#### re: **Grading Plan Review** Proposed Commercial Building Addition 2 Bill Leathem Drive - Ottawa

date: May 24, 2022

file: PG5257-MEMO.05

□ Lot Grading and Drainage Plan, Project No. CP-20-0023-01, Drawing C101, Revision 2 dated May 24, 2022.

D07-12-22-0045

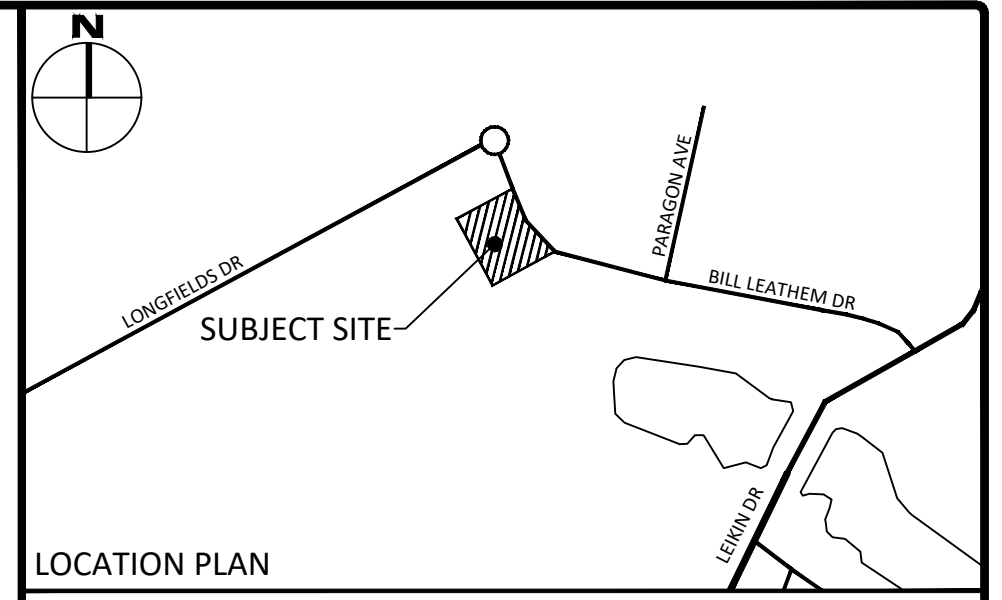
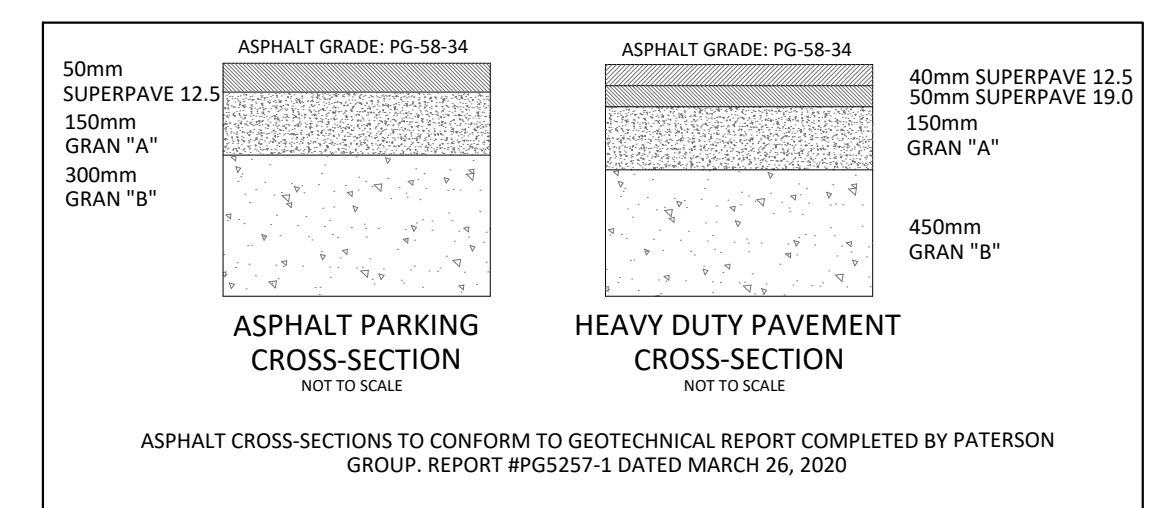
Based on our review of the above noted plans, it is understood that the finish floor level FFL for the proposed building addition will be at geodetic elevation 91.7m. In addition, the USF of the proposed building addition will be at geodetic elevation 90.18m. It is further understood that there is an existing manhole MH7 located in close proximity to the central portion of the proposed northern foundation wall of the building addition.

Based on our review of the available information and drawings, it is understood that the horizontal separation between MH7 and the central portion of the northern foundation wall is approximately 0.8m. Also, the vertical separation between the invert level of MH7 and the USF of the proposed building addition is 2.7m.

Based on our review, the lateral support zone of 1.5H:1V for the proposed building addition adjacent to the existing manhole is not protected. Therefore, the USF of the effected footings should extend down to the bottom level MH7 or it can be placed on a near vertical lean concrete infill trench (17MPa, 28-day compressive Strength). The lean concrete infill trench shall extend a minimum 150mm from the face of the footing on each side. Furthermore, the lean concrete infill trench shall extend at least 2.0 from the face of MH7 from each side. The lean concrete trench can then be stepped upward at a slope of 1H:1V. Further details are provided on Figure 1 –Concrete infill trench detail, attached to this memorandum.
